APPENDIX D – DRAINAGE MAP

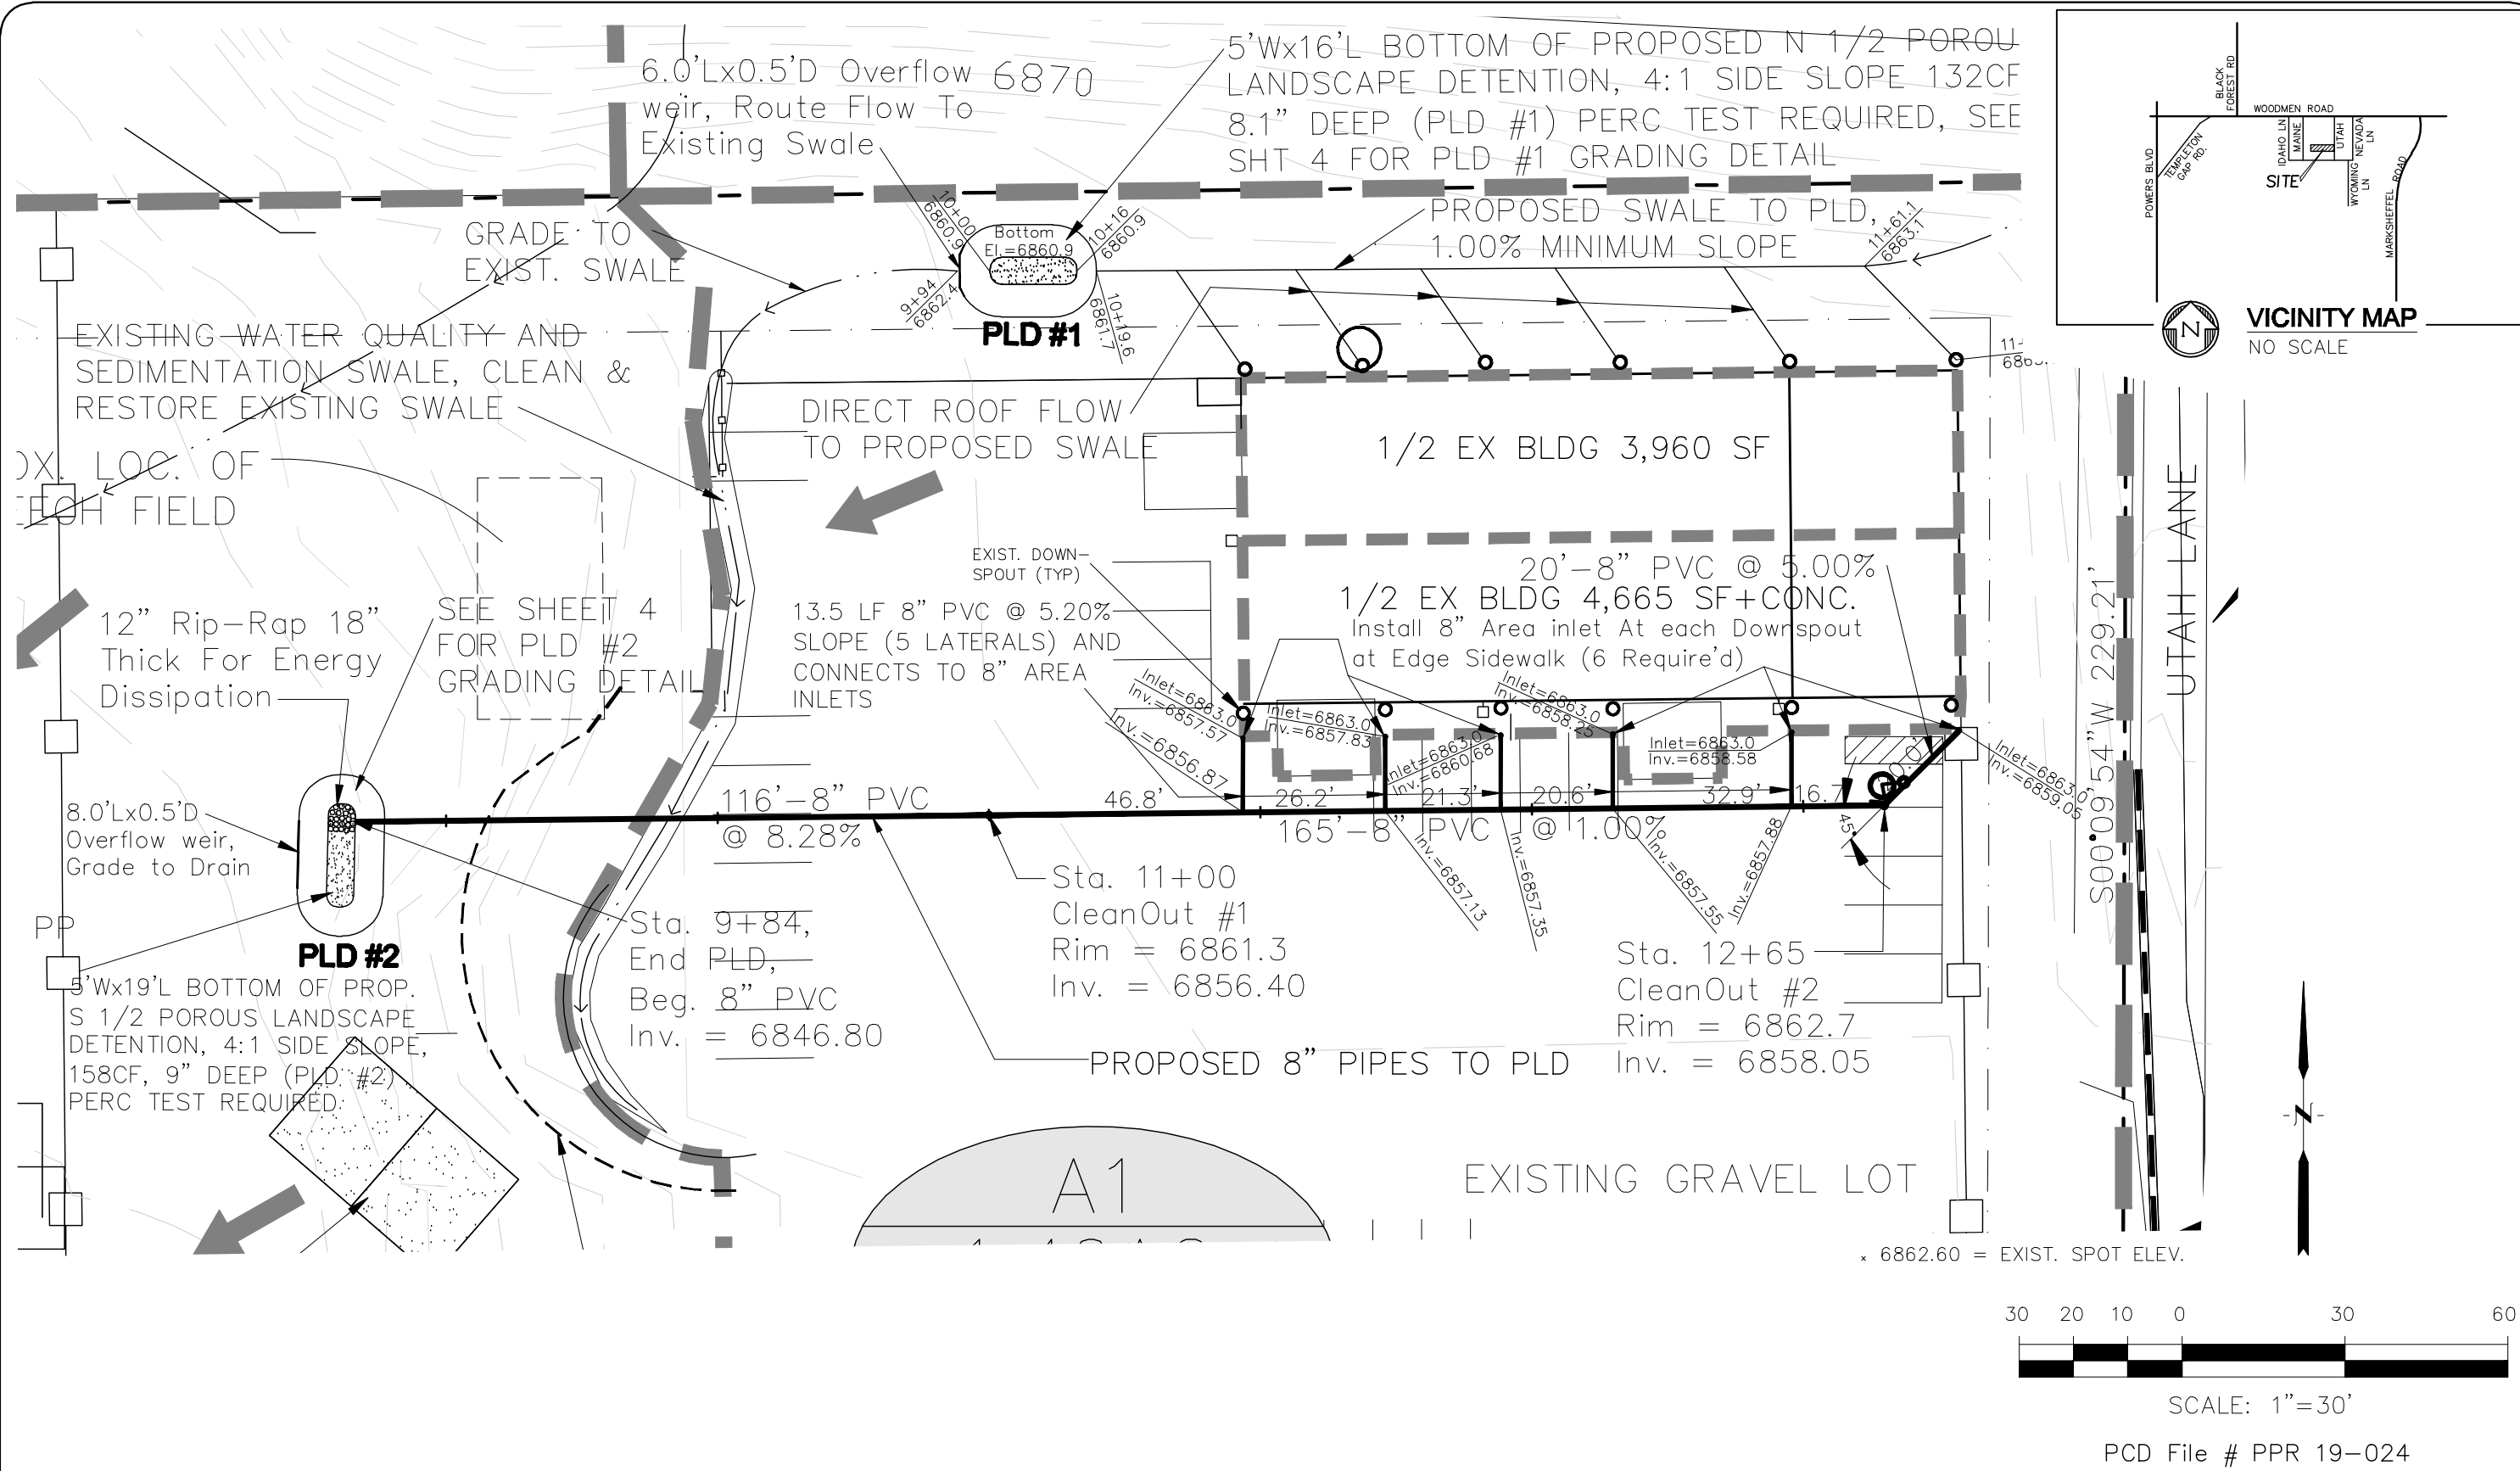
Based on previous site visits, it does not appear that this swale exists.
The swales exist and will cleaned and restored, discussed in report

The site plan shows a gravel drive area in the western portion of this lot with the storage area. Show that on the drainage map. Basin A2 must be treated with WQCV.
The 40'x24' gravel drive is shown in basin A2, WQ is discussed in report

Show the entire basin OS-1
All of basin OS-1 is shown

This scale is incorrect. Revise.
Scale is 1" = 100', fixed bar scale

It does not appear that the runoff from the parking lot is reaching PLD #2. How is this area treated?
Flow is directed to the 2-existing grass swales, to be cleaned and restored

The drainage basin design does not appear to match the site conditions. Revise the drainage basin layout to more accurately reflect current and proposed site conditions.
The basins now match site conditions
40'x24' gravel drive has been added

Storm Sewer Profile

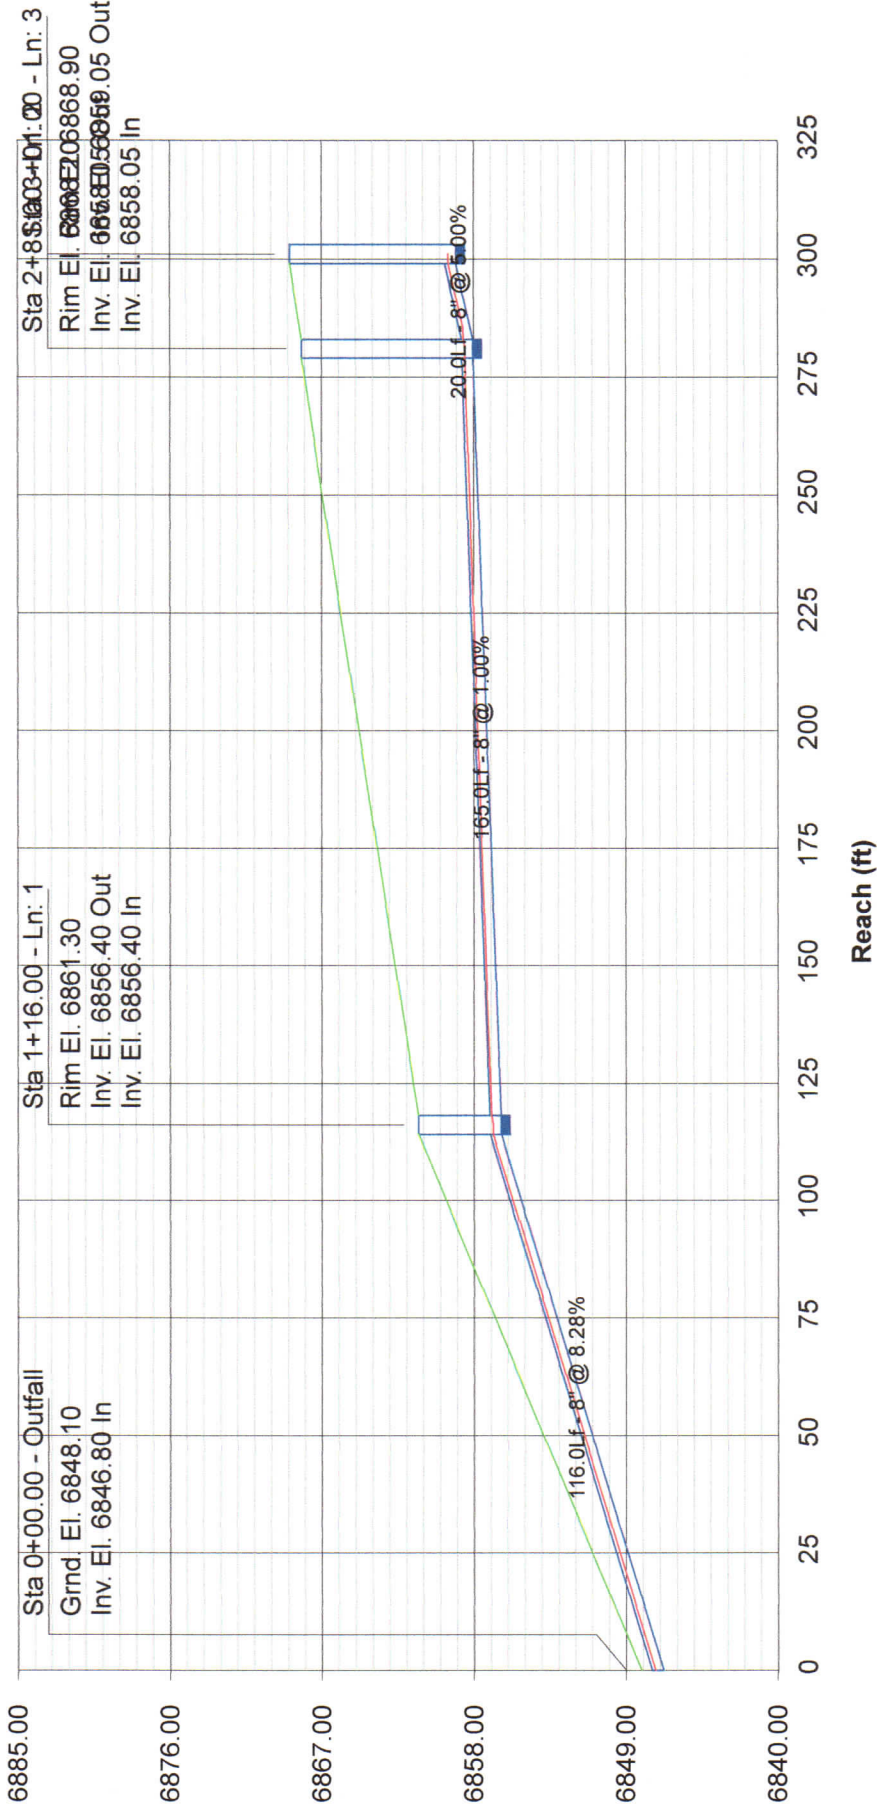
Provide a legend for the line types
Called out line designations on the sheet

APPENDIX D – DRAINAGE MAP, STORM P&P, PLD #1 & #2

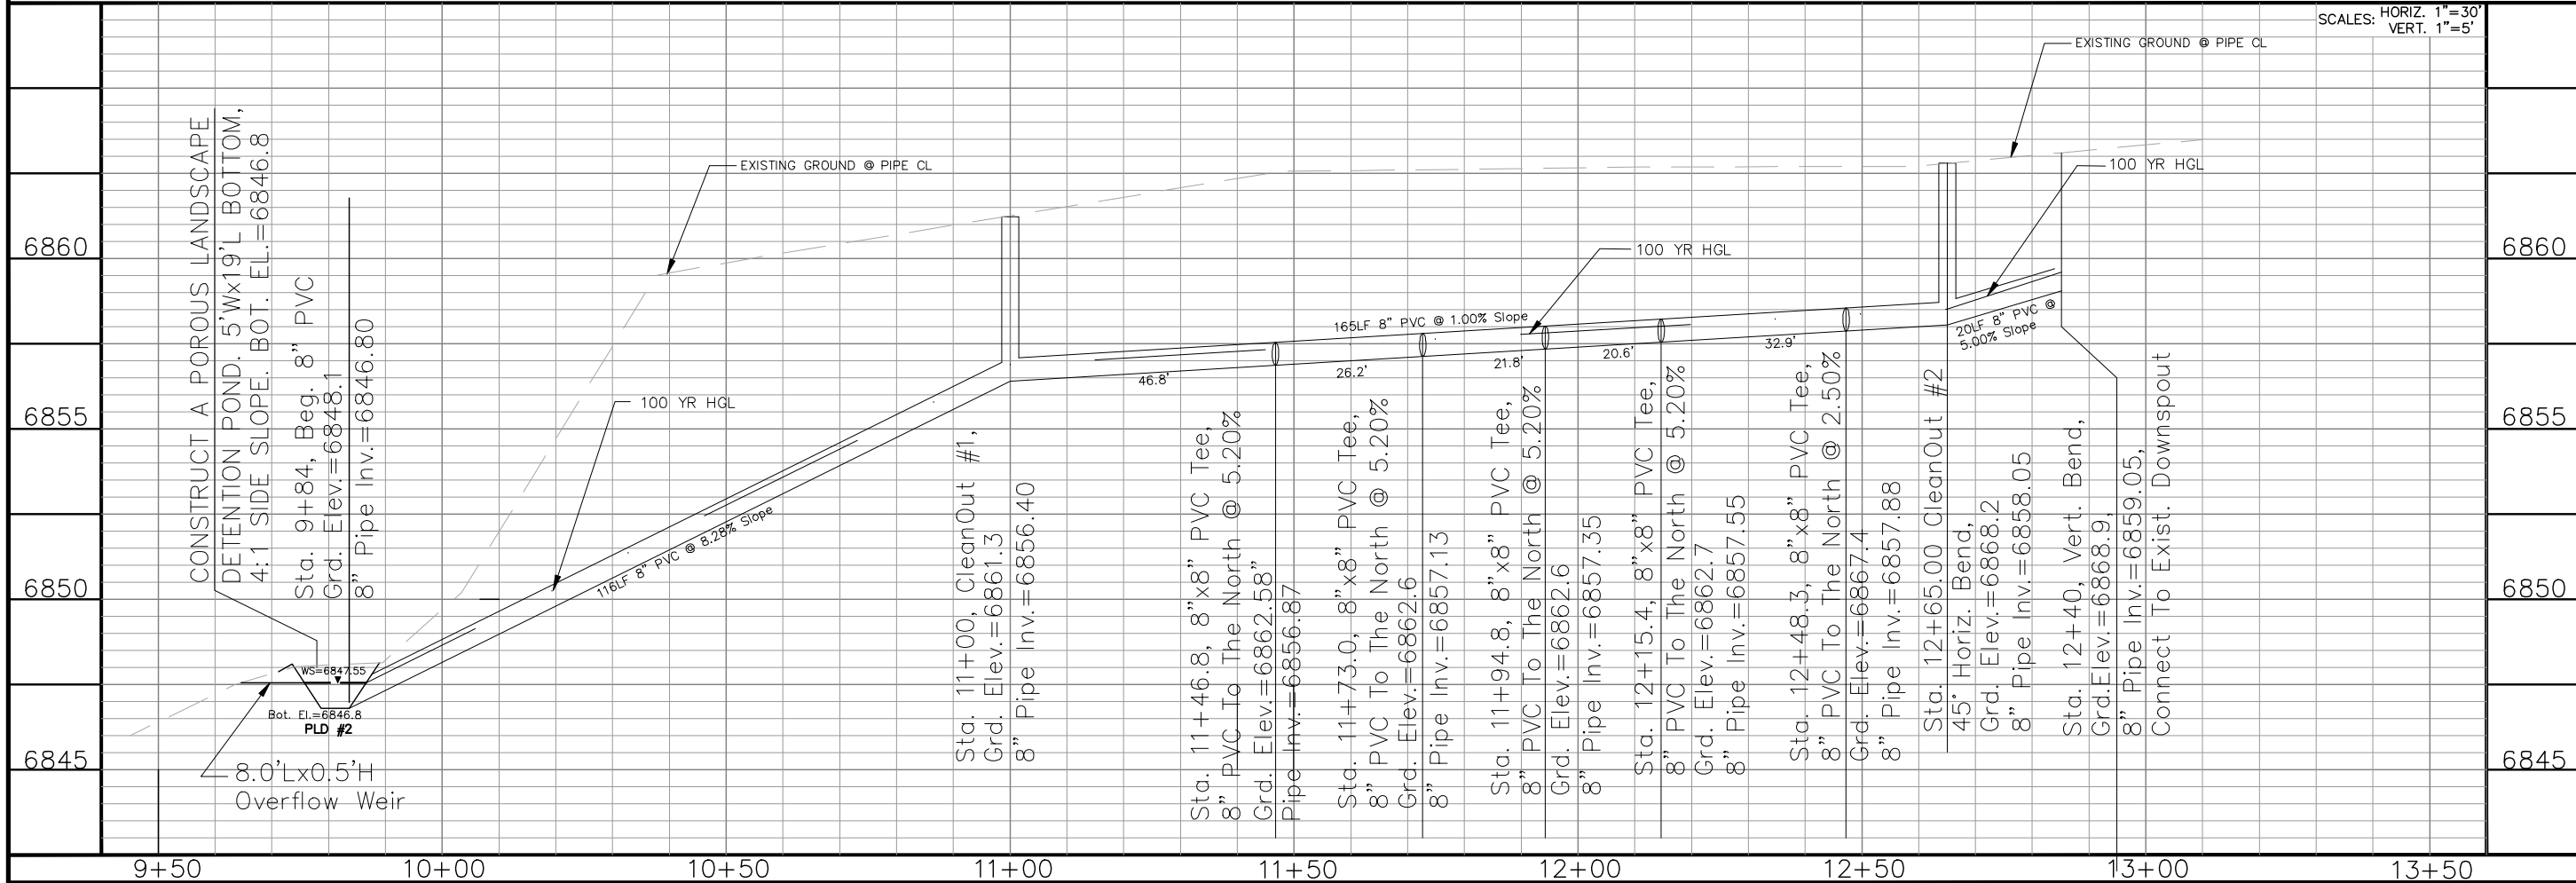
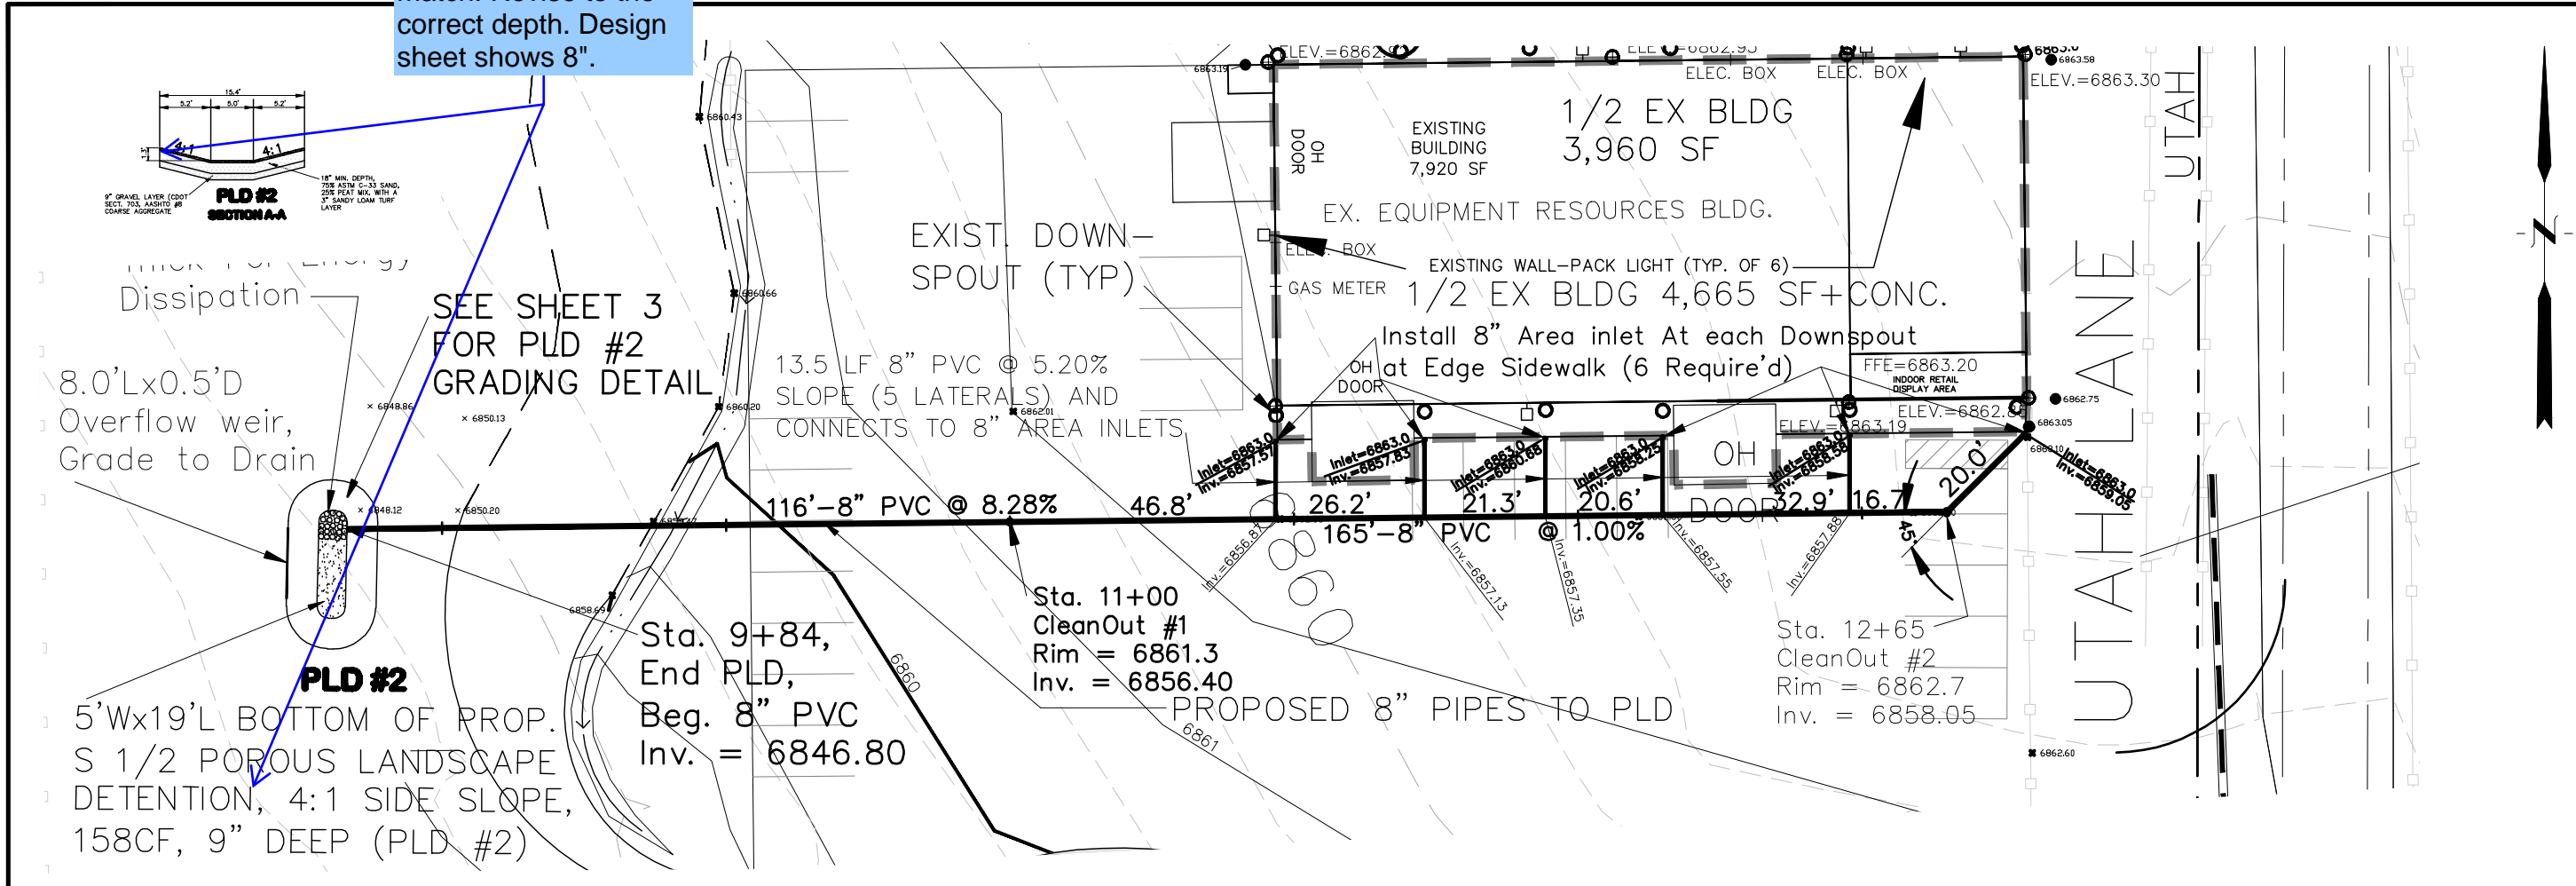
These depths do not match. Revise to the correct depth. Design sheet shows 8".

These depths do not match. Revise to the correct depth. Design sheet shows 8".

Discussed at our meeting and it is OK

Discussed at our meeting and it is OK
